Date: 20/08/2018
Our Ref: 132449-4
Via: Email

Hurlstone Agricultural High School (SSD 17_8614): Response to Submissions

Response to Agency Submissions

Figure 7 – Pre Development Indicative Depths of Inundation & 1% AEP Flood Contours

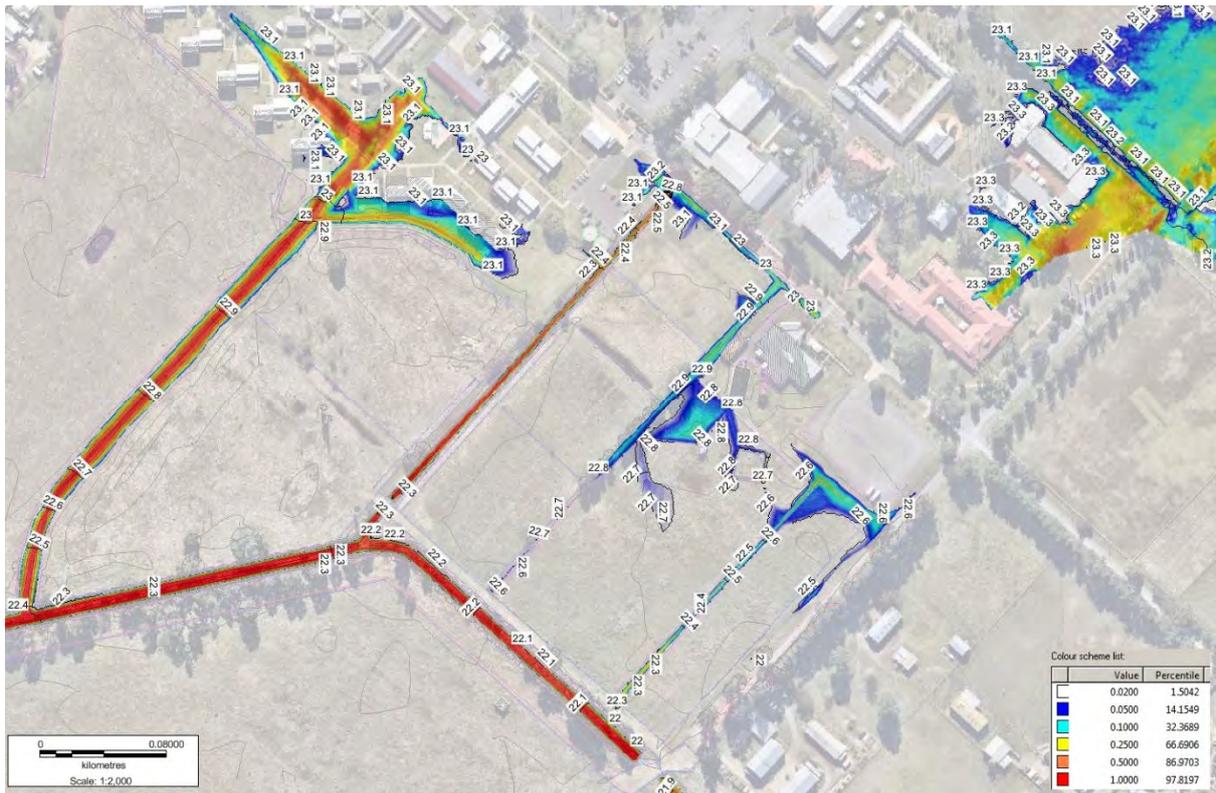
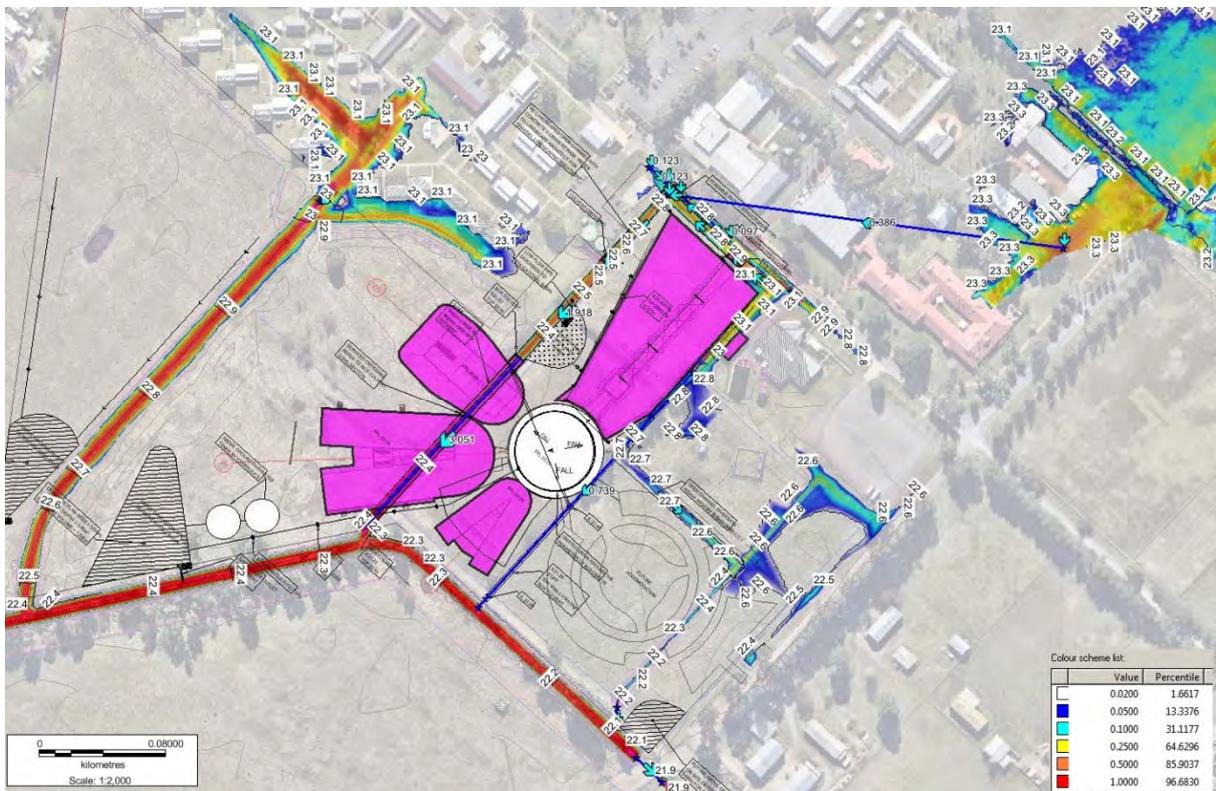
Issues Raised by Agency Submissions		Proponent's Response
	<p>especially a concern as the channels are piped underneath the buildings on the western side which provides an additional hazard.</p> <p>(b) Figure 7 (Pre-development) does not show the existing pipe from the university as shown in Figure 6. Clarification is sought on whether the pipe was modelled in the pre-development case. As the pipe is existing it should be include in the pre-development case.</p> <p>(c) The afflux map presented in Figure 9 is confusing to read. A legend should be on the figure as Well as a simplification of how the afflux is presented. The text boxes with impact are confusing as to the exact location and the extent of the flood is hidden by these text boxes as well.</p> <p>(d) The assessment should provide a sensitivity analyses to determine the potential impacts from climate change on flooding behaviour, as per the flooding requirements issued in the SEARS for the proposal.</p>	<p>considered necessary given the inland location of the property and distance from the coastline.</p>
